Subject: CPHR Advice - Elf Mushroom Farm and Substrate Plant - Renewal and relocation of processing plant (MP08_0255-Mod-4) (Hawkesbury City)

CPHR advice - Elf Mushroom Farm and Substrate Plant - Renewal and relocation of processing plant (MP08_0255-Mod-4) (Hawkesbury City)

Figure 6: NSW State Vegetation Type Map and field validated vegetation zones

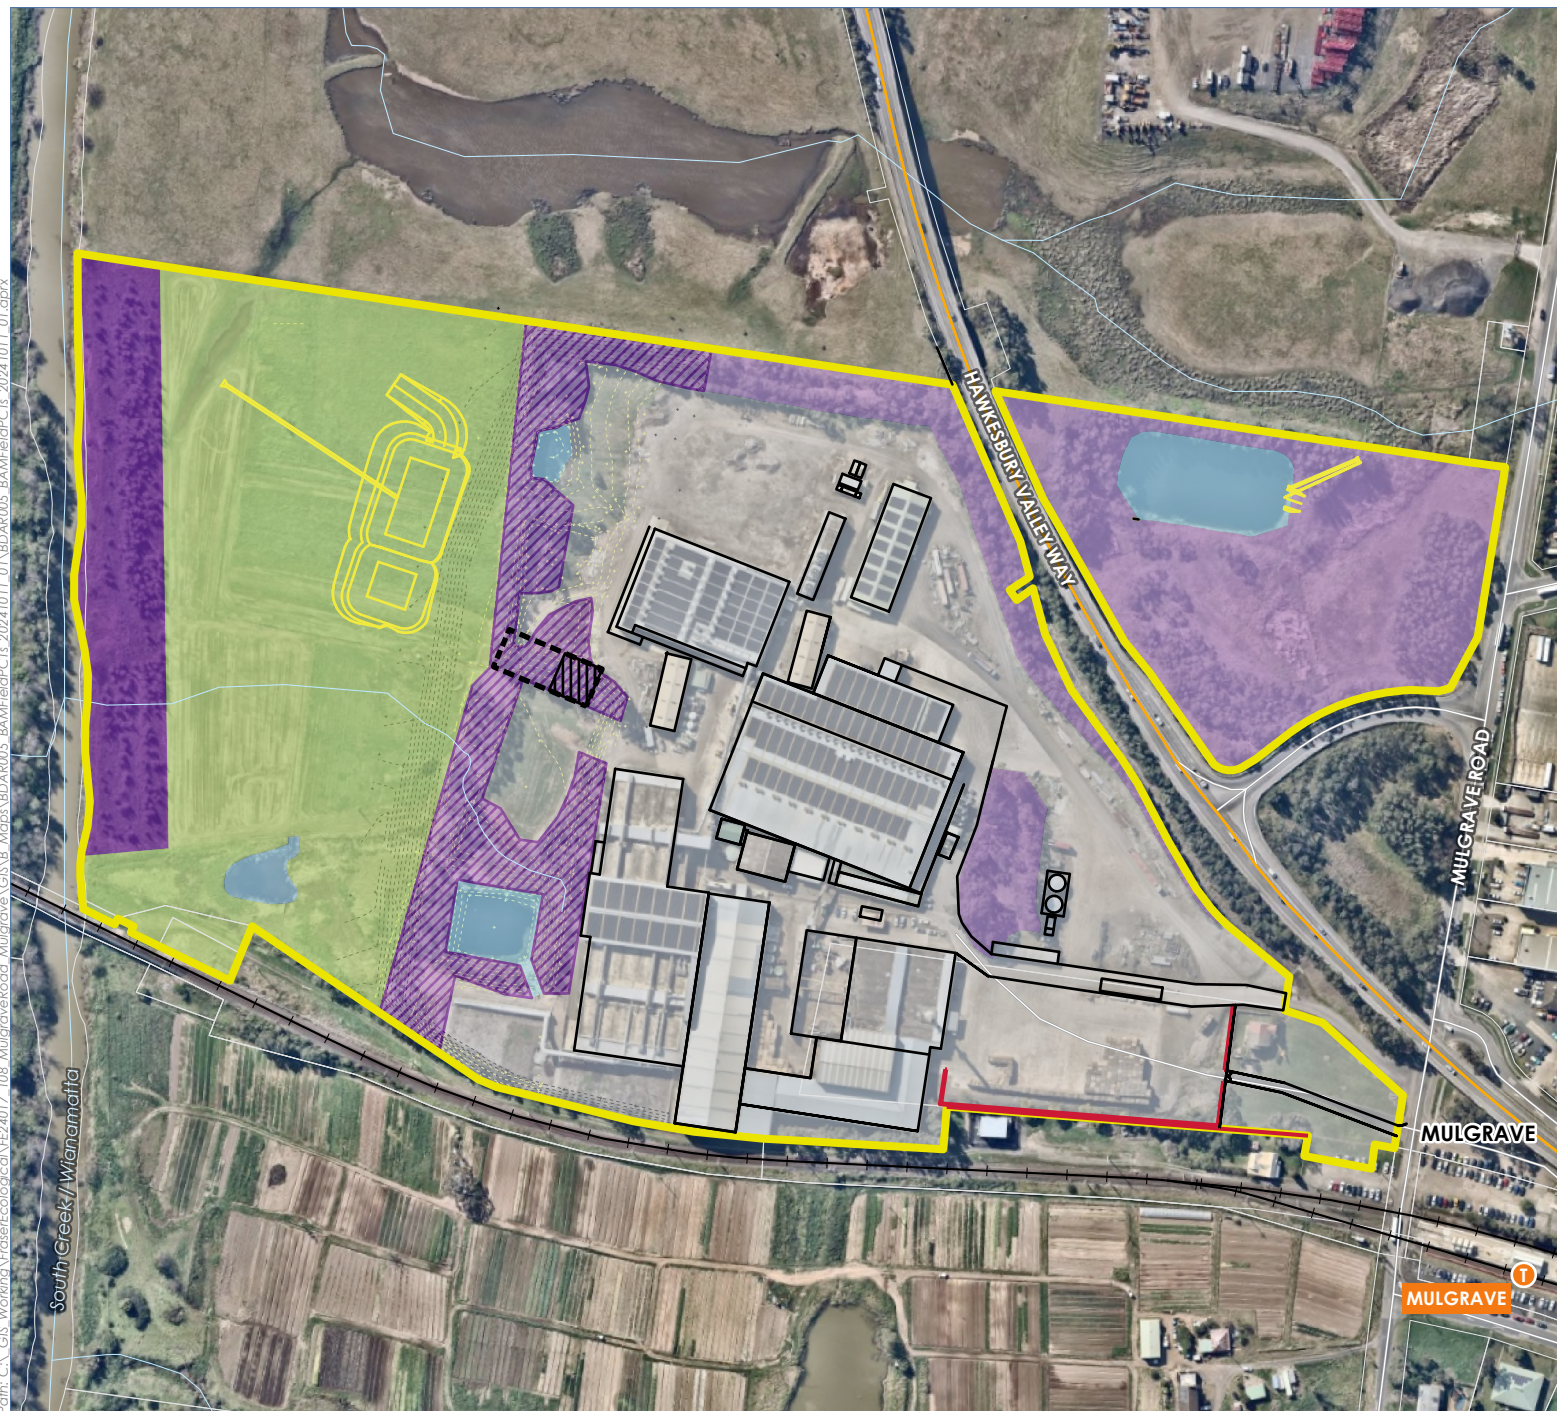
| 7. | BDAR – PCT identification | <p>The BDAR does not provide justification for the best-fit Plant Community Type (PCT) selection and the selected PCT in the BDAR has several Threatened Ecological Communities (TECs) associated with it.</p> <p>Recommended actions:</p> <ul style="list-style-type: none"> • The BDAR is to provide justification for the PCT selection. Refer to section 4.2.3 in the BAM. |

| 8. | BDAR – avoid and minimise | <p>The BDAR has not addressed how impacts to the western tree corridor, identified as PCT 4025 in the BDAR, have reasonably avoided or minimised. The BDAR must demonstrate genuine efforts have been made to avoid and minimise impacts as set out in sections 6.2 and 6.12 of the BC Act and section 7 of the BAM.</p> <p>Recommended action: Consideration should be given to reducing the area proposed to be filled to avoid impacts to the existing tree corridor along the western edge of the site.</p> |
